16 December 2020

Our reference D20/187055

Council's submission to SSD-10451 for the Royal Institute for Deaf and Blind Children (RIDBC) Centre of Excellence at Macquarie University campus

Culloden Road Frontage - Plan

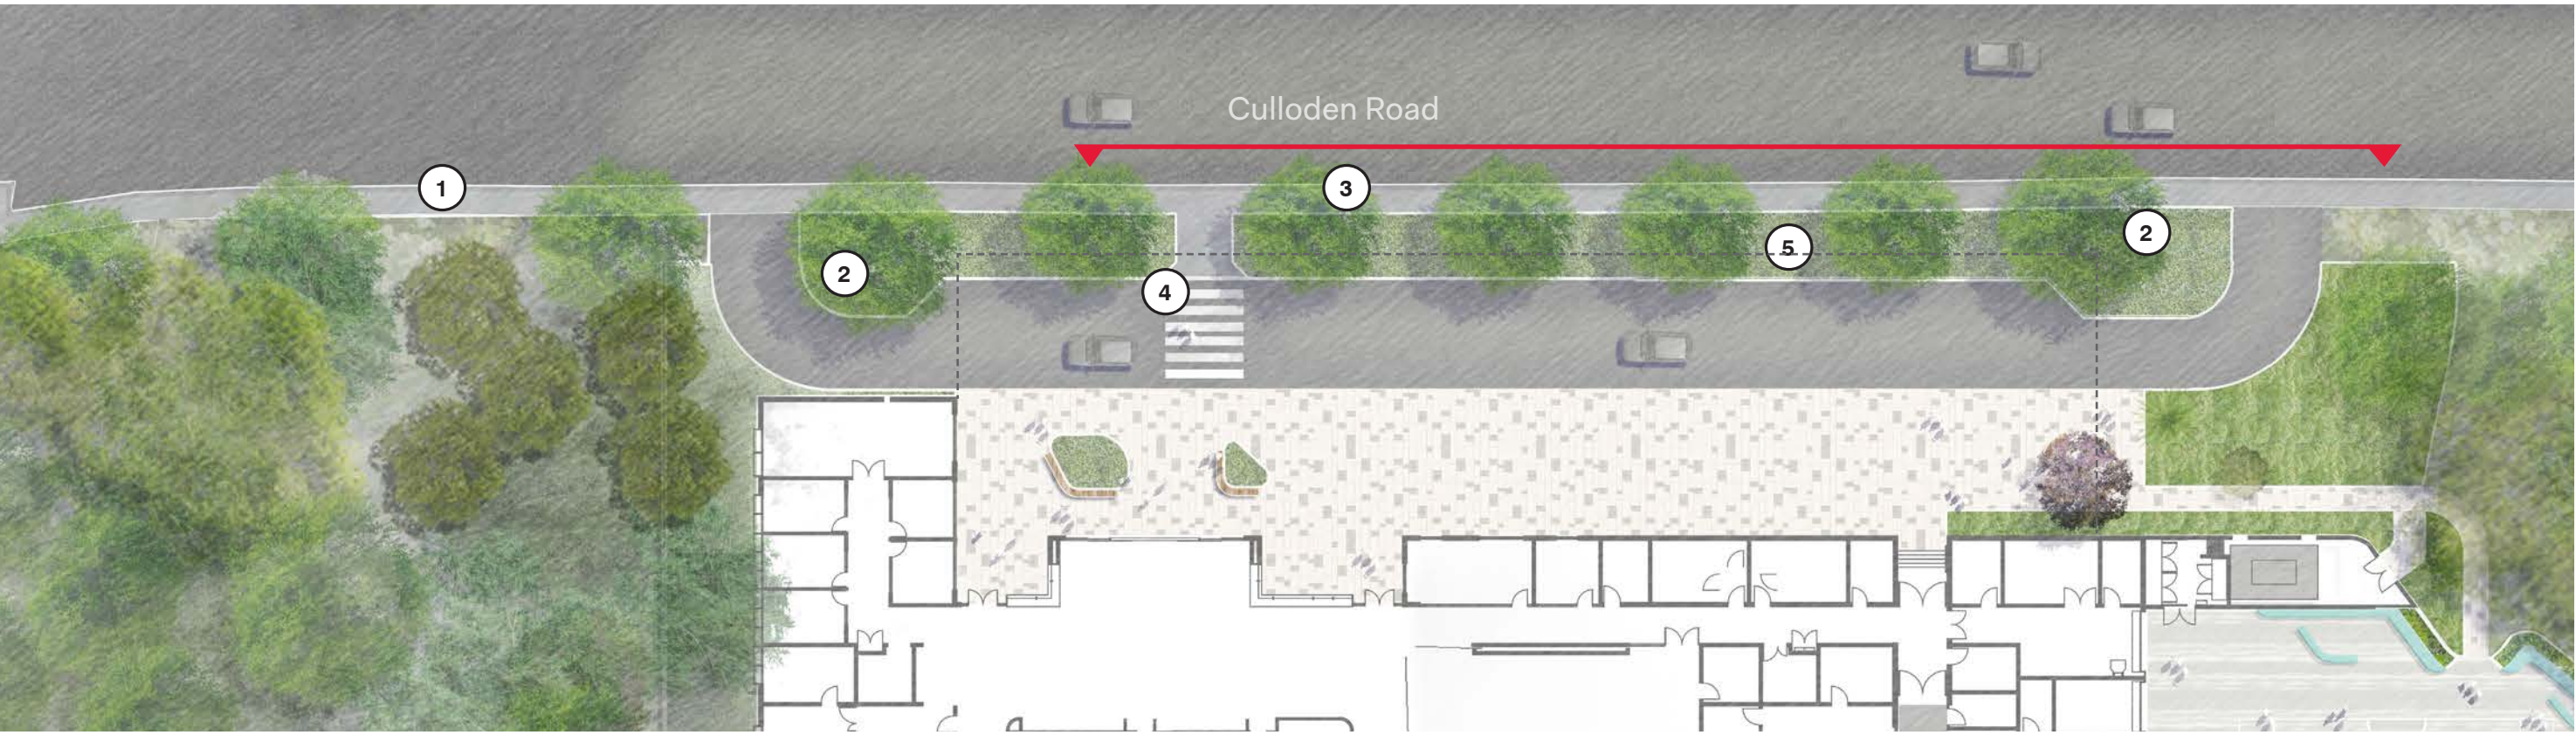
The proposed interface to Culloden Road is dominated by vehicle access, circulation and parking areas with a 95m long drop-off zone running parallel to the street in front of the school entry. The amount of at-grade car parking in front of the school building results in a large extent of hardstand surface and limits the opportunity for soft landscape planting. The school entry is setback by approximately 18m from the public footpath and located behind the drop-off zone in an undercroft area.

It is a poor outcome for the public domain interface as the design will adversely impact on the amenity of the public domain with a large extent of hardstand area for vehicles, reduce the legibility and visibility of the school entry and compromise the wayfinding for first-time visitors. The configuration of the drop-off zone and car parking will also increase the conflict between vehicles and pedestrians as the current design clearly prioritises vehicle circulation and car parking over pedestrian movements and amenity.

- Relocate the drop-off zone to either side of the school building, so that its visual impact can be mitigated by existing clusters of trees to the north or south of the development.
- Orient the drop-off zone to be perpendicular to Culloden Road instead of being parallel to the frontage. By reconfiguring and reorienting the drop-off zone, it will significantly reduce its impact to Culloden Road, increase the presence of the school building and potentially allow more existing trees along the frontage to be retained.
- Reduce the number of vehicle access point off Culloden Road to a single access point combining entry and exit.

- Where large existing trees are presented, maintain a minimum street setback of approximately 15m to assist with the retention of some trees; where significant trees are unaffected, it is encouraged to reduce the street setbacks, increase the presence of the school and allow the building to address the street.
- Retain existing trees in the street setback zone and maximise deep soil landscape planting to soften the building mass.
- Provide a forecourt fronting Culloden Road with seating and public art installation to provide a welcoming arrival experience and increase the street activation.

**Consulting Services  
Building Entry - Plan**

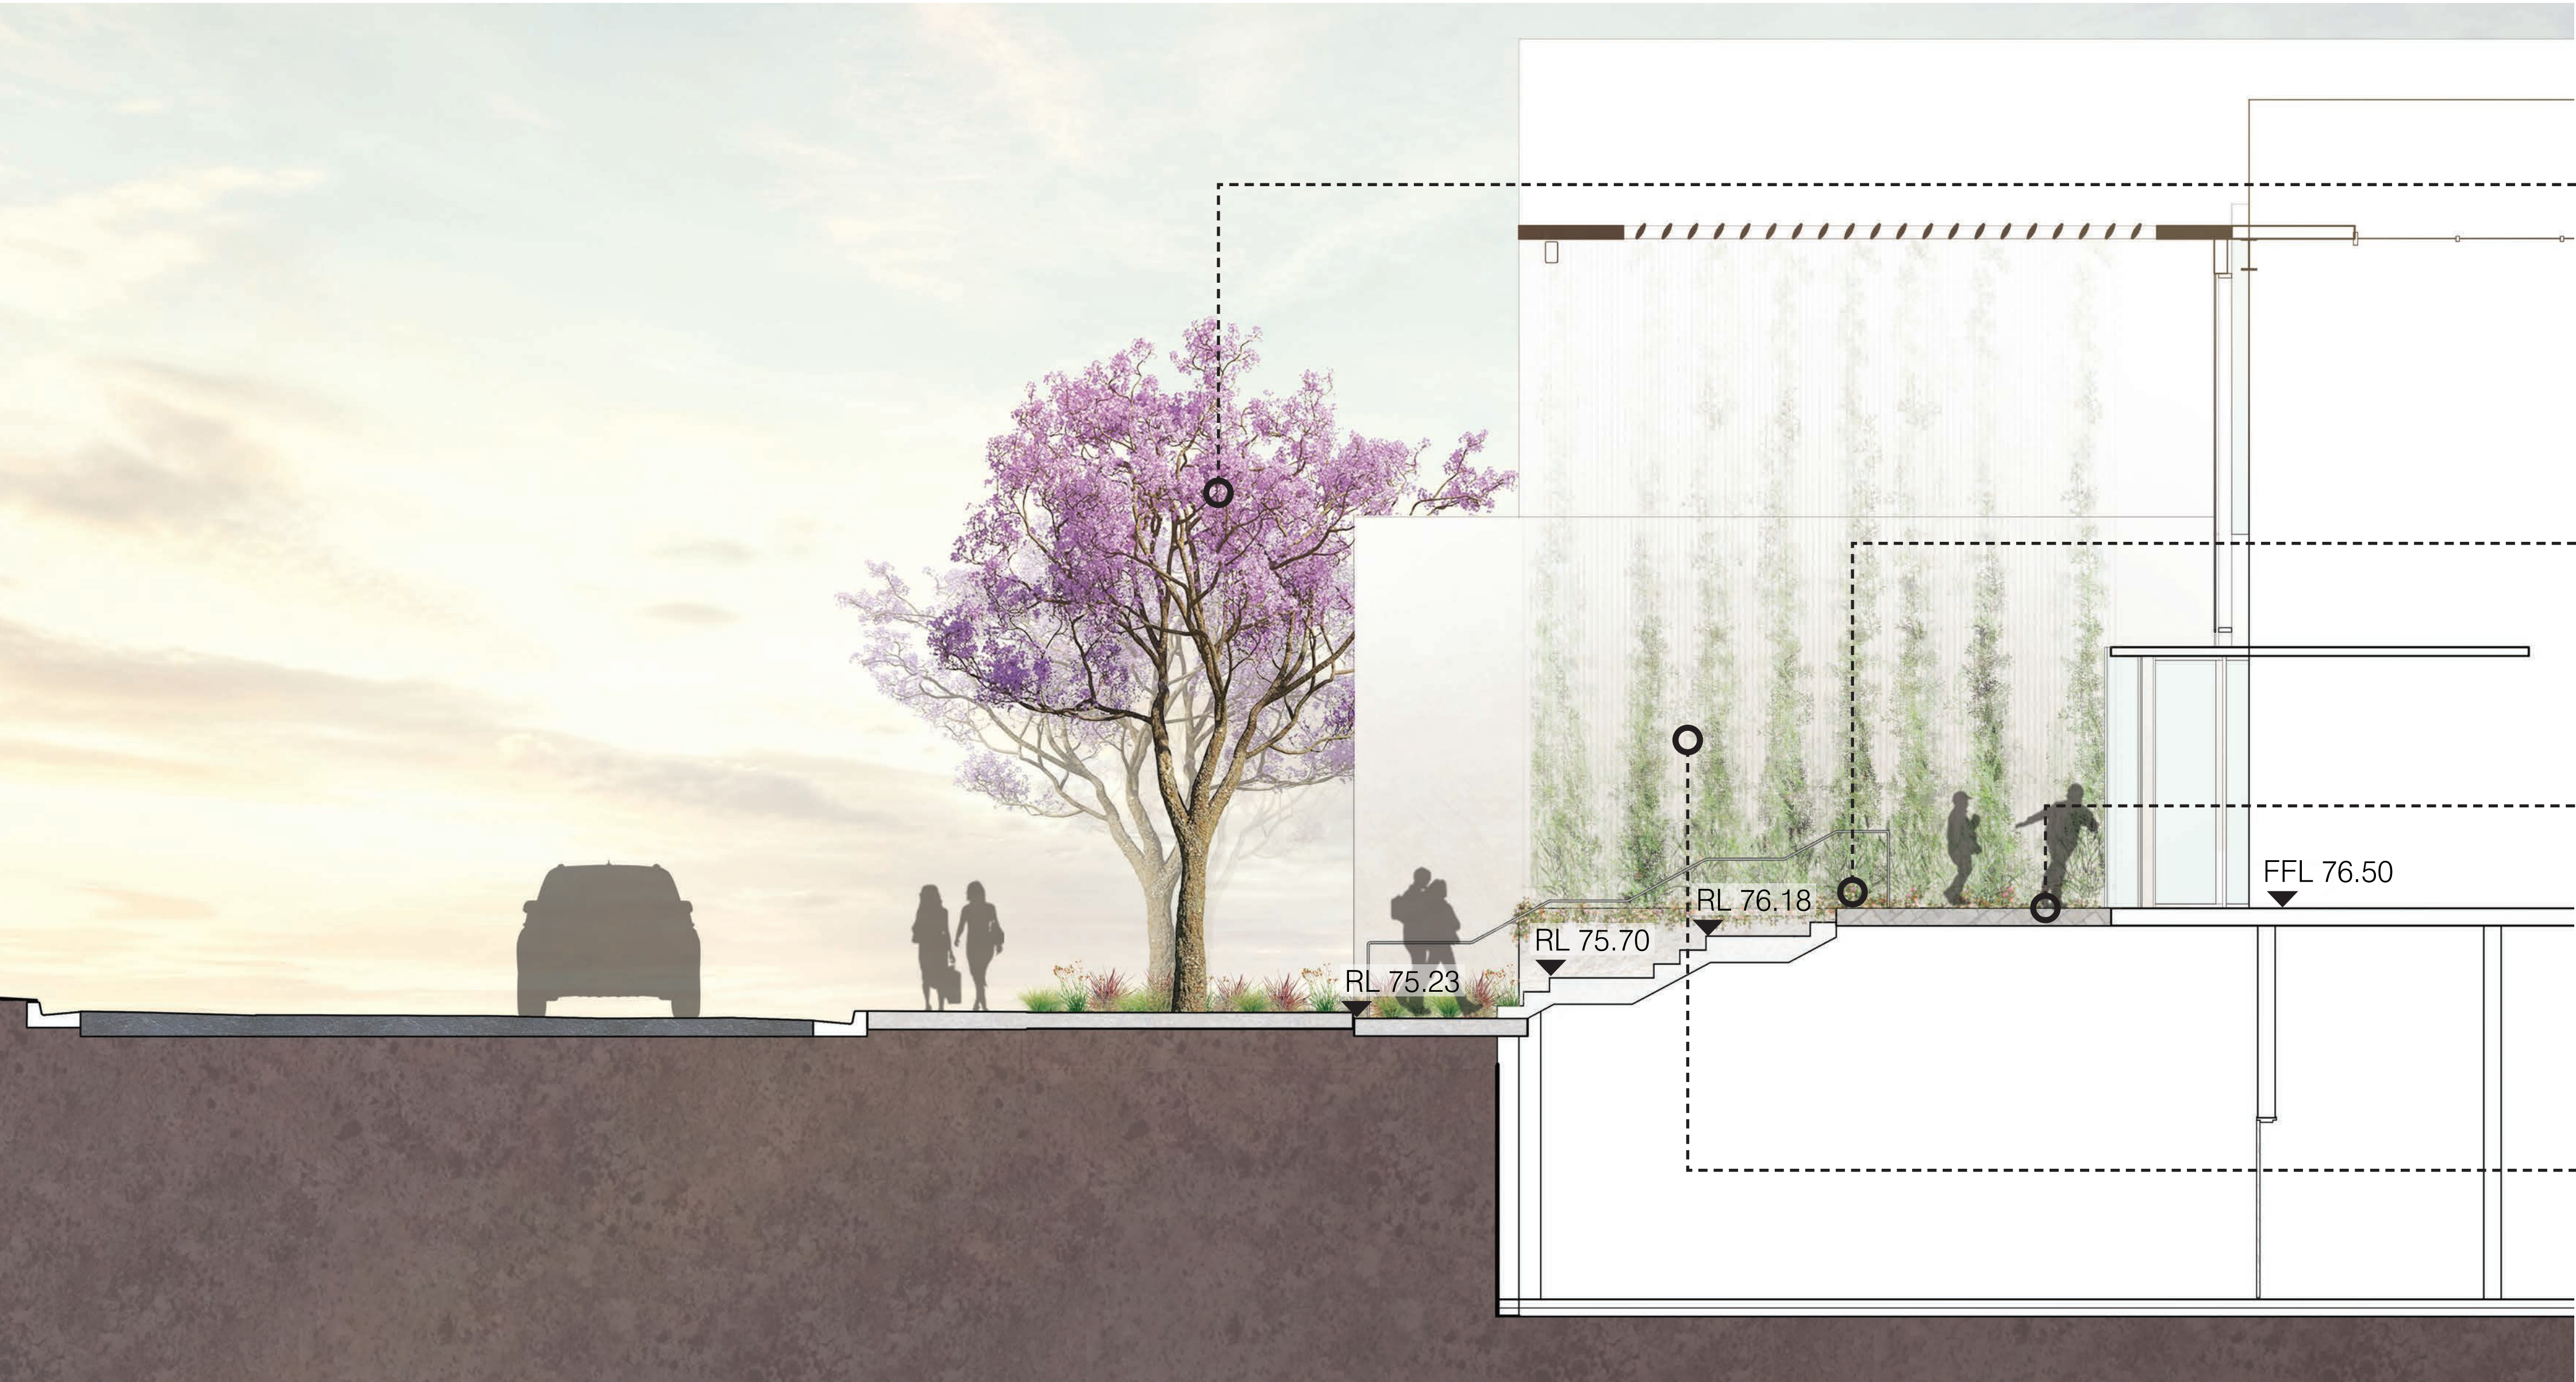
- It is unclear if the port cochere off Culloden Road is to have kerb running the full length of the port cochere or if the road pavement is to sit flush with the pedestrian forecourt. If kerb is not proposed, then bollards are required to be implemented to avoid the risk of collisions with vehicles and pedestrians.

LONGITUDINAL SECTION
CL 1

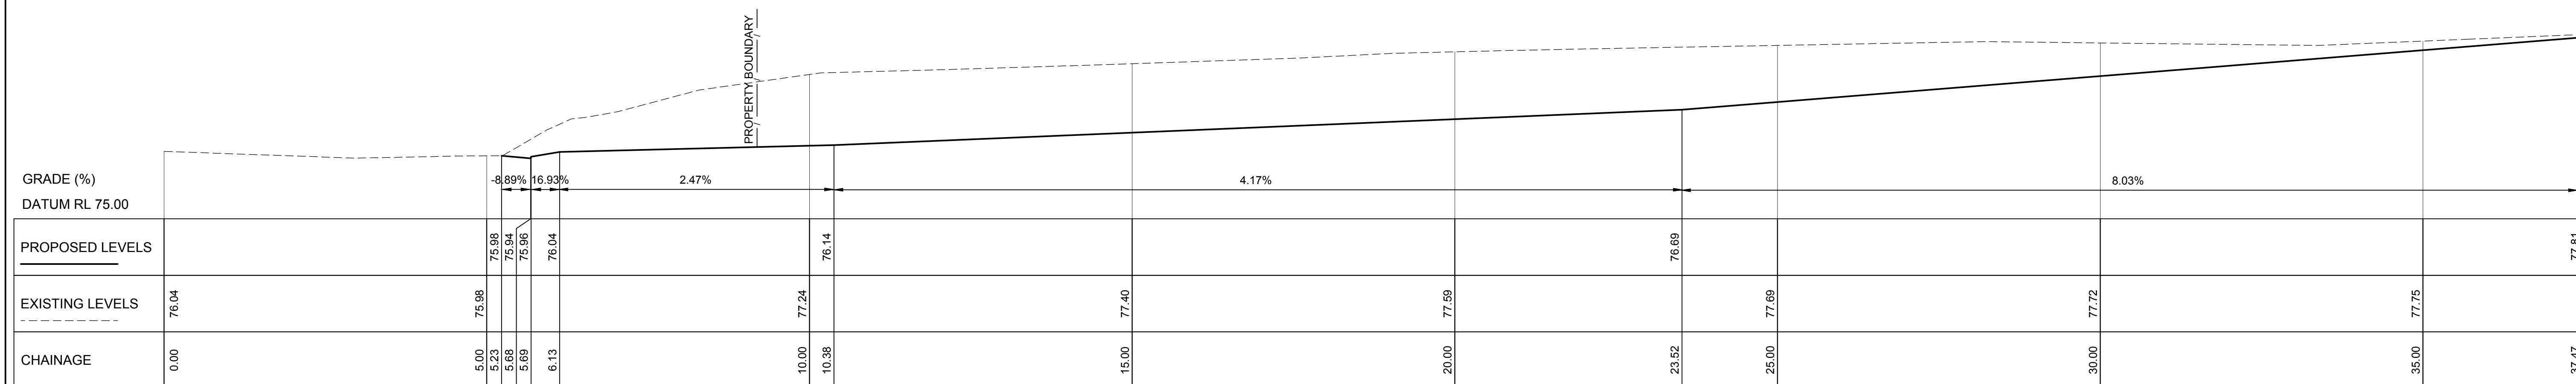
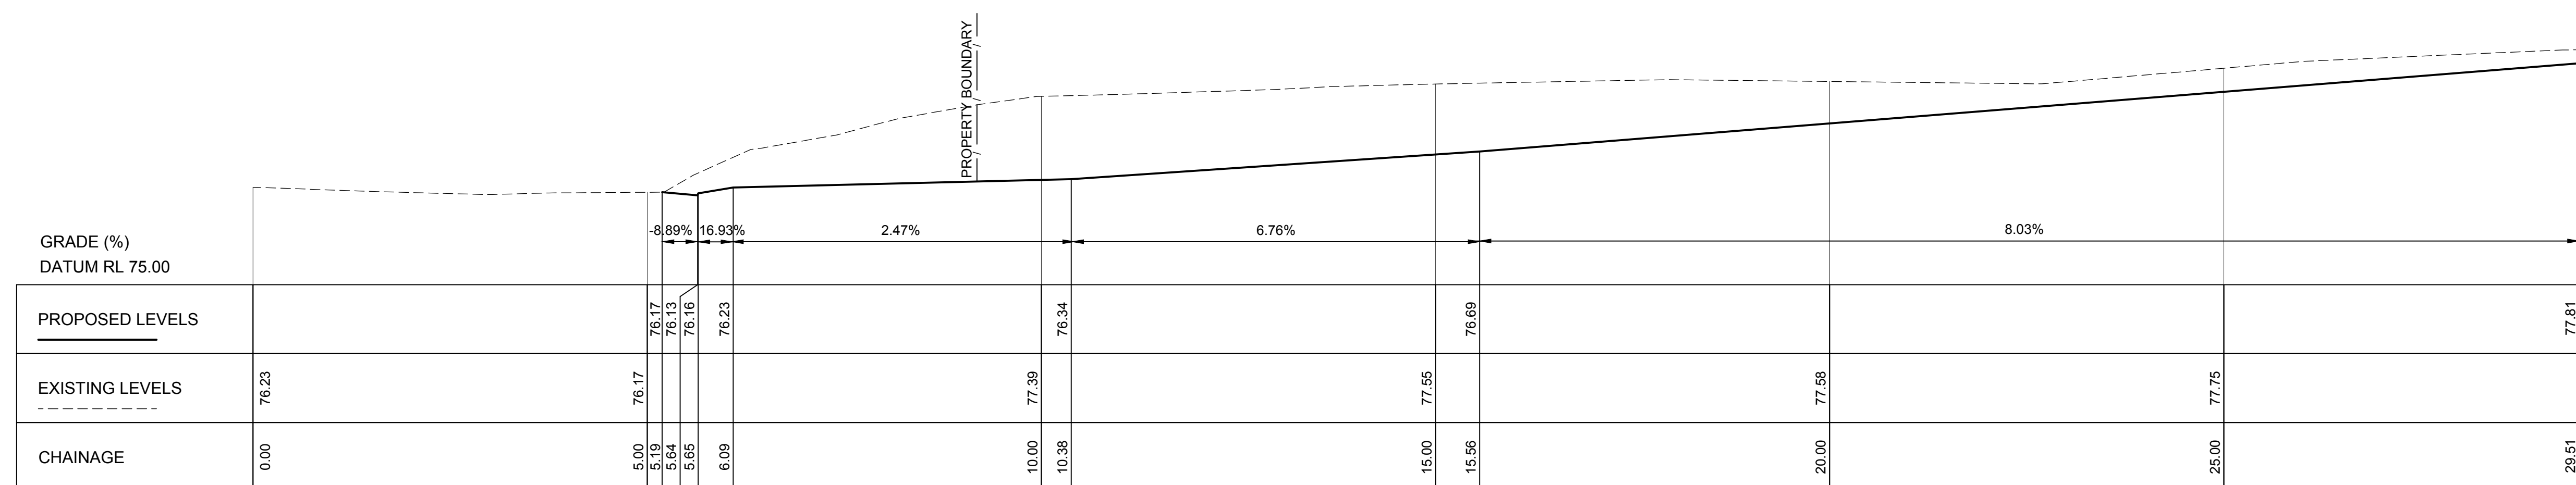
- In order to assess the susceptibility of vehicles to scraping as they pass over the proposed access the applicant shall submit longitudinal sections along each side of the proposed new access drawn at 1:20 Natural Scale. The section shall show the existing and proposed levels to AHD along the vehicle path from the centre of Culloden Road through the gutter/layback to the proposed new driveway. The driveway is to be designed using the B99 Ground Clearance Template from AS2890.1
